## APPENDIX **B**

### Submissions

**Peter McManus - ASA RESPONSE: Wagga Wagga Base Hospital Redevelopment (NSW-MA-187)**

**SSD 5237-2012 – PROPOSED PHASE 2 AND 3, WAGGA WAGGA BASE HOSPITAL DEVELOPMENT, EDWARD STREET (HW14), WAGGA WAGGA.**

Wagga Wagga Base Hospital
Redevelopment
Edward Street
Wagga Wagga NSW 2650
Site Traffic Plan

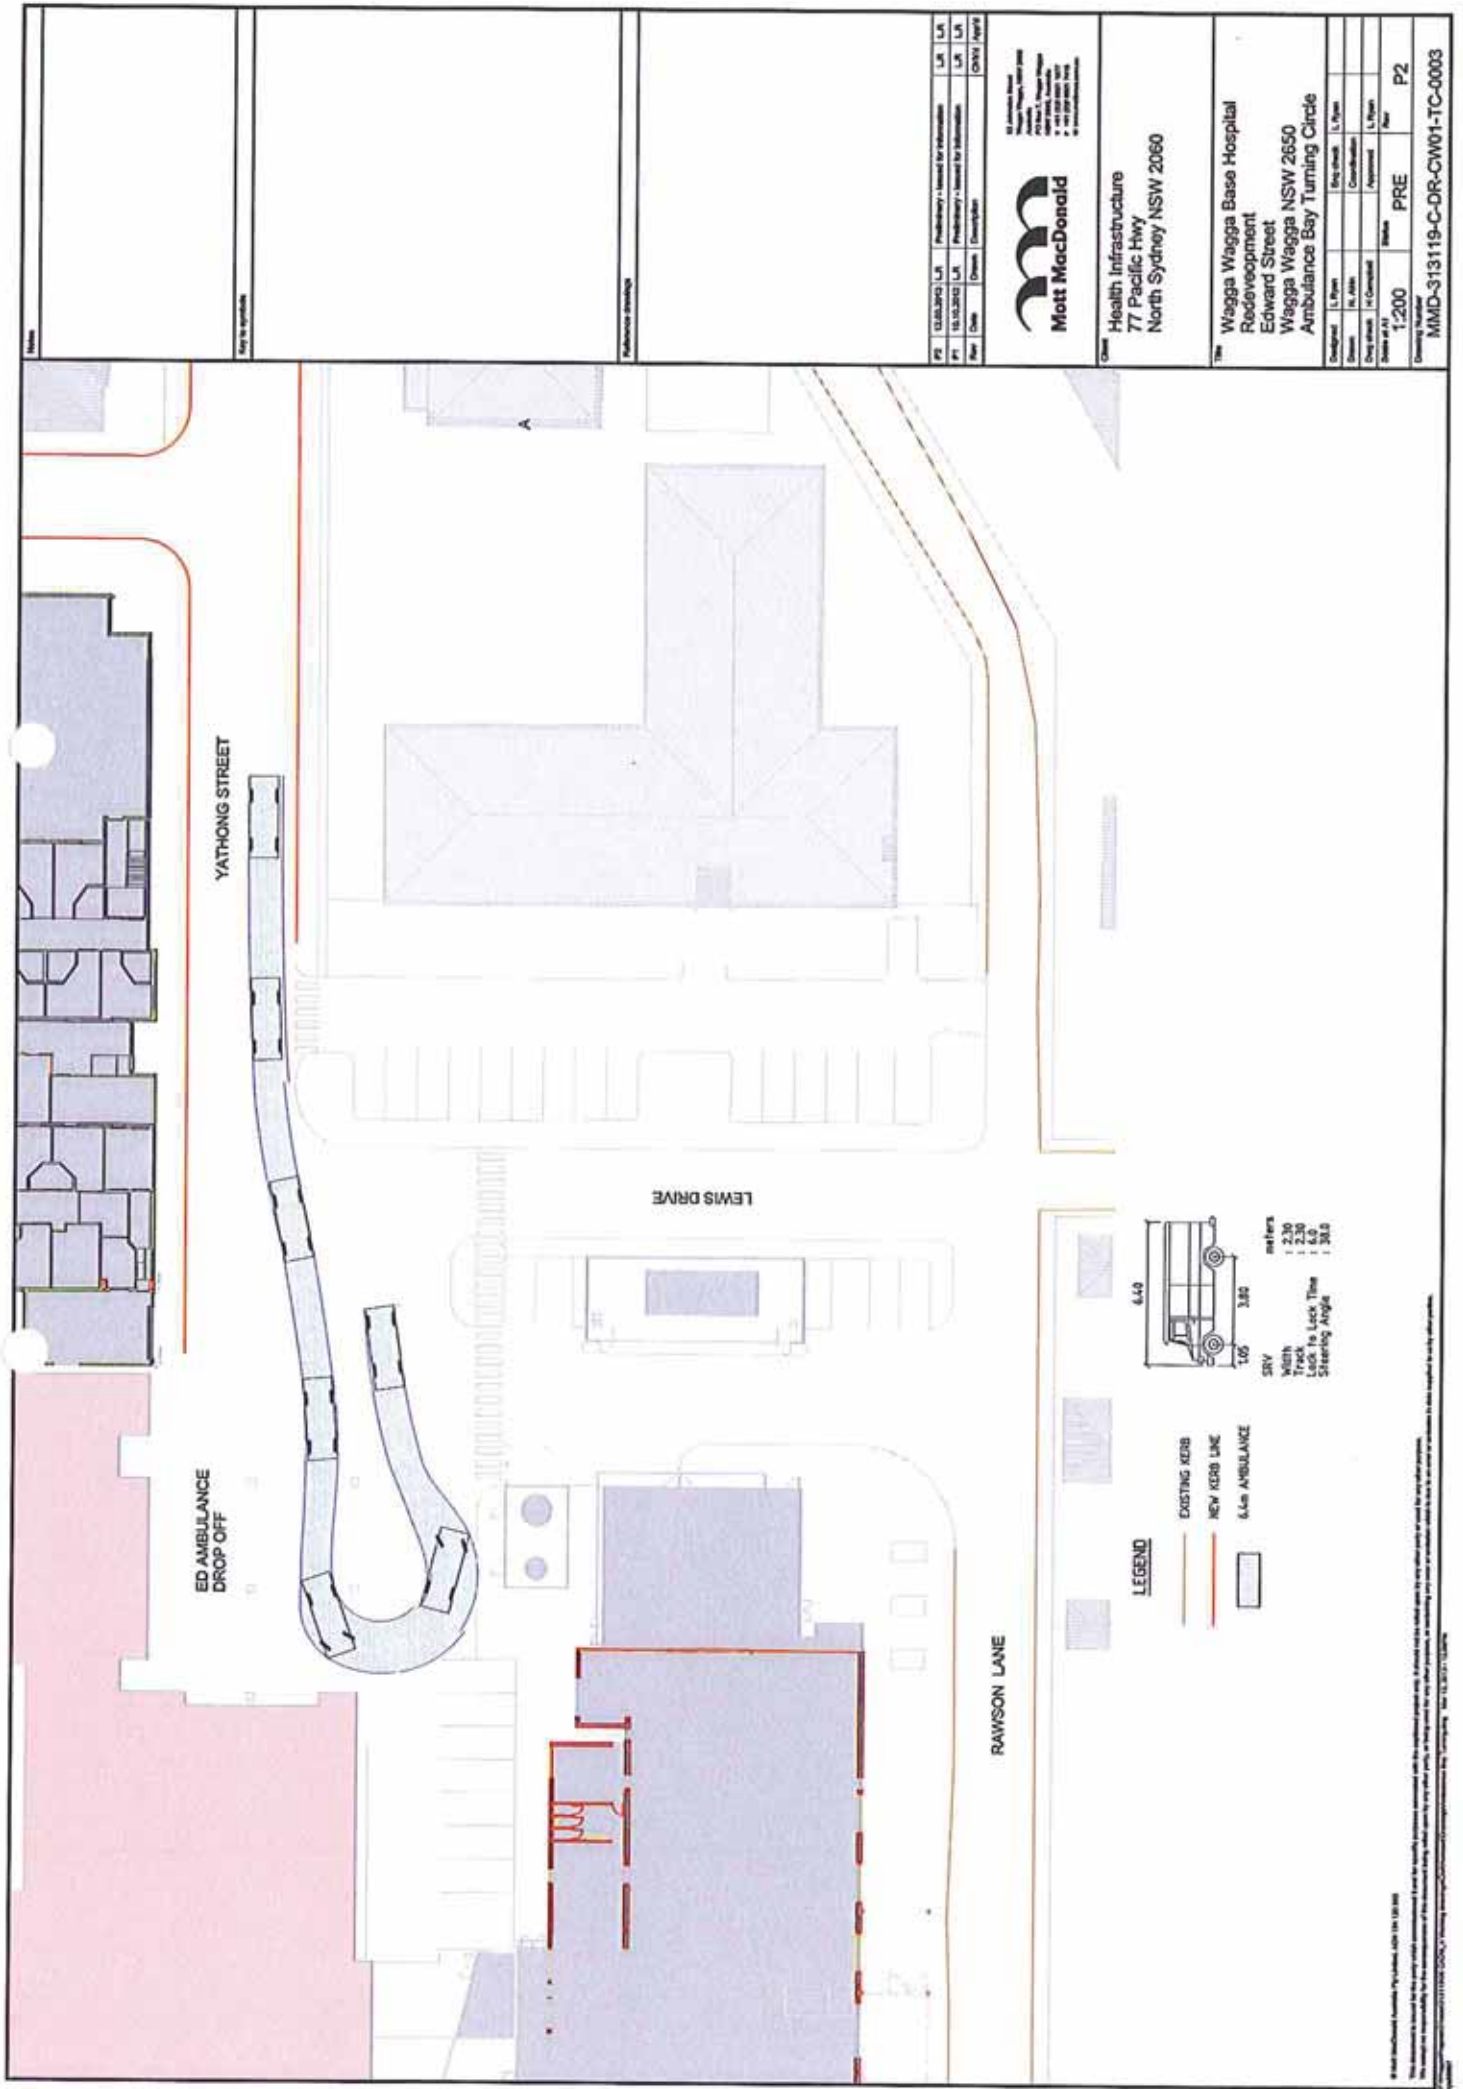
The current proposal represents significant changes to the traffic arrangements for the finished redevelopment of the hospital site to that included as part of the original Concept Plan and the traffic arrangements for Stages 1 and 1A. These changes include;

- The relocation of the ambulance access to the Emergency Department to the rear of the hospital building,
- The deletion of the internal road way linking Yathong Street to Docker Street and the signalised intersection treatment at Docker Street,
- The retention of the new driveway to the loading docks from Docker Street as a permanent access rather than a temporary arrangement till the internal road way was constructed as previously indicated,
- Lewis Drive to Edward Street to be available for two-way vehicular movement not one-way as previously proposed,
- The access driveway and Channelised Right Turn (CHR) treatment in Edward Street to allow for right turn access for all light vehicles, not restricted to emergency vehicle only as previously proposed.

Due to the geographical location of the hospital site within the urbanised area of Wagga Wagga and the existing road network a significant proportion of the population would access the site from the south along Docker Street. The latest layout of the hospital redevelopment removes the option of the road way link between Yathong and Docker streets and denies vehicular access for the general public from Docker Street. This deletion and the orientation of the proposed building and the public access area towards the north and east will focus increased traffic volumes, including emergency vehicles, through Brookong, Murray and Yabtree Streets, which are residential streets.

Between the concept plan, the application for Stages 1 & 1A and the current application for stages 2 and 3 the reliance on access to the Sturt Highway (Edward Street) and via Lewis Drive has increased. Initially as part of the concept plan Lewis Drive was proposed to be one-way into the hospital and the access to Edward Street was left turn ingress only with a continuous central median along Edward Street. The application for stages 1 & 1A included a right turn from Edward Street which was limited for use by emergency vehicles to allow for ease of access to the Emergency Department. Now as part of the current application Lewis Drive is to be 2 way and the right turn bay from Edward Street is for general access purposes. Initially the right turn access from Edward Street was requested for convenient ambulance access to the Emergency Department which is now located to the rear of the hospital site as part of the current application.
